5 April 2018

Austen Quarry Extension Project - Modification 1 (SSD 6084 MOD 1)

I refer to your email received 7 March 2018 in regard to a modification to the State Significant Development Approval SSD6084 for the Hy-Tec/Austen Quarry and the request for Council comment on the application.

Figure 2: Approved and proposed overburden emplacement boundaries

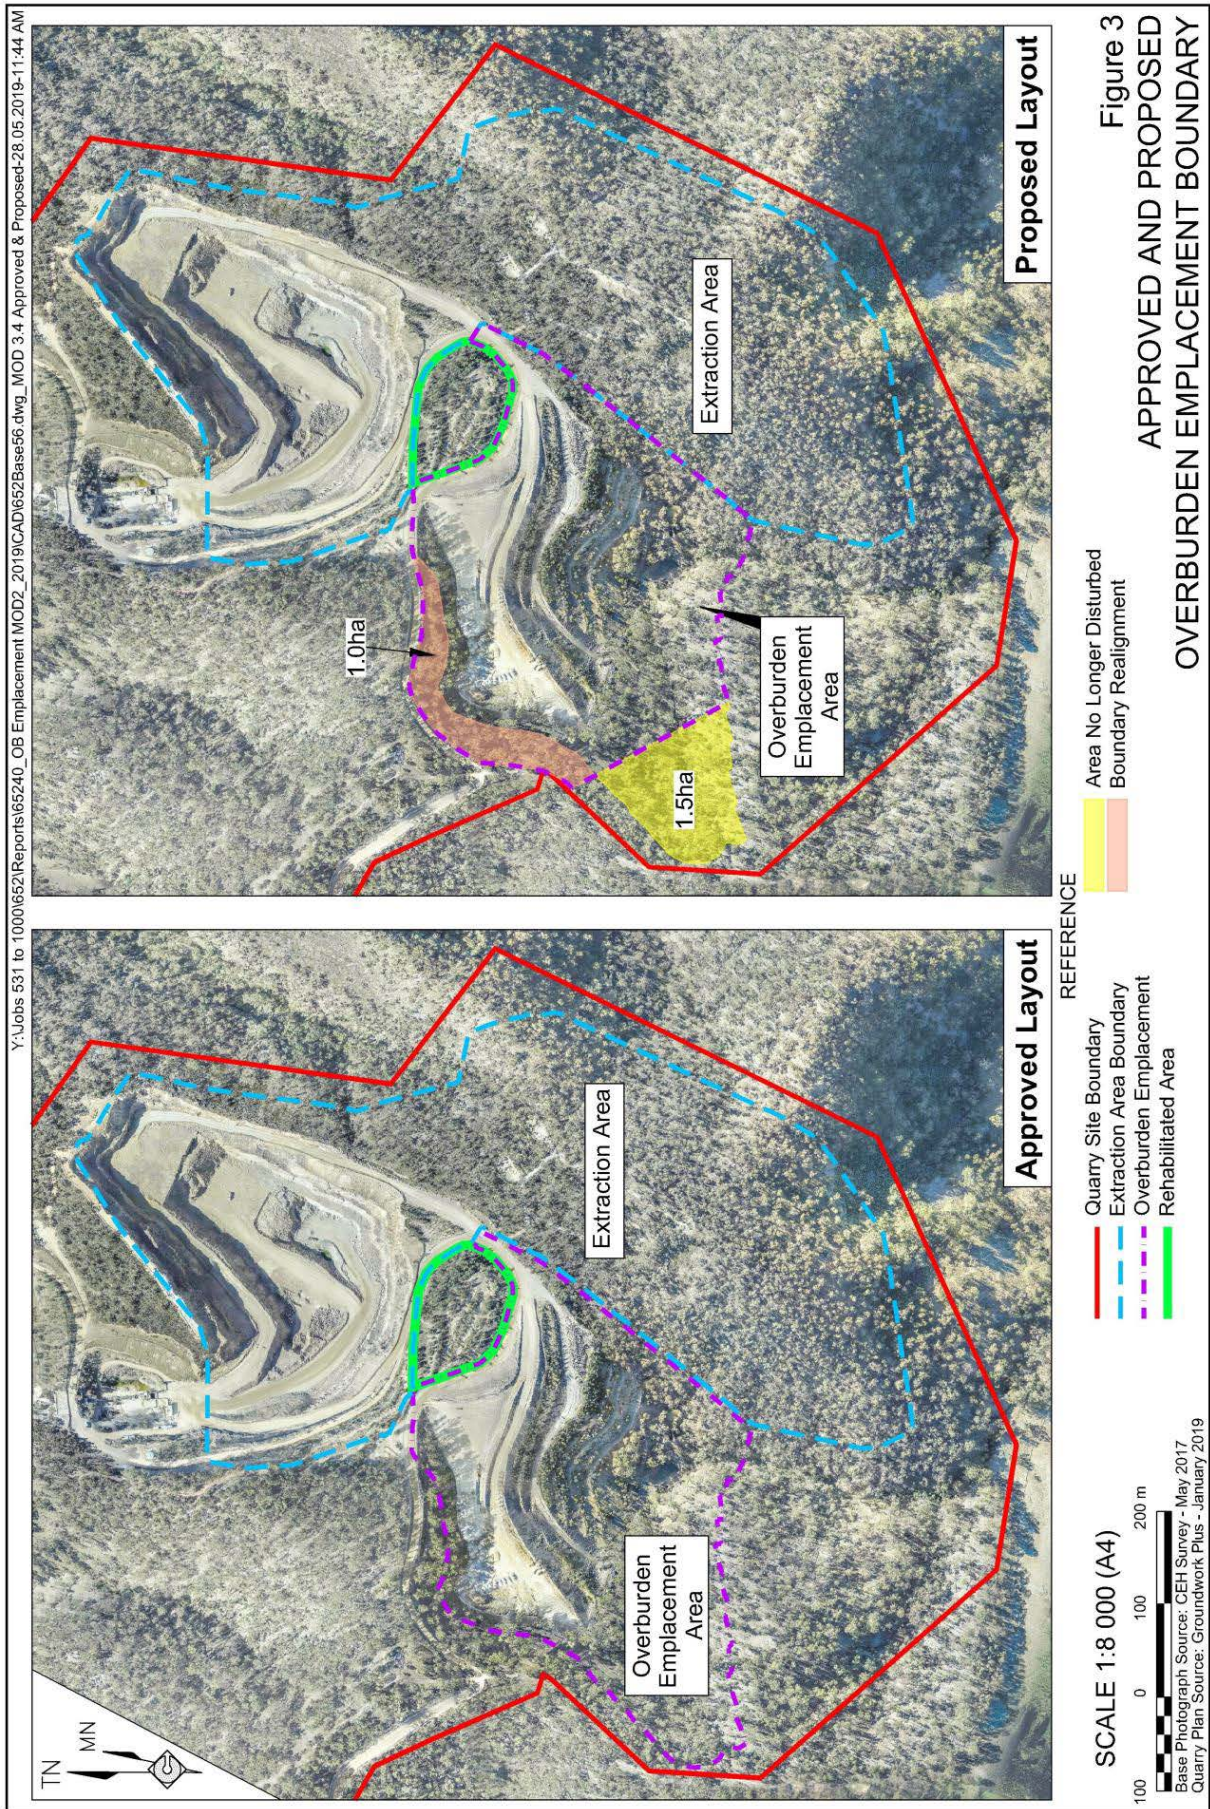
3. Overburden Emplacement Boundary

Council is satisfied that the overburden emplacement boundary be modified as it involves a reduction in the offset area previously predicted in the SSD6084 consent.
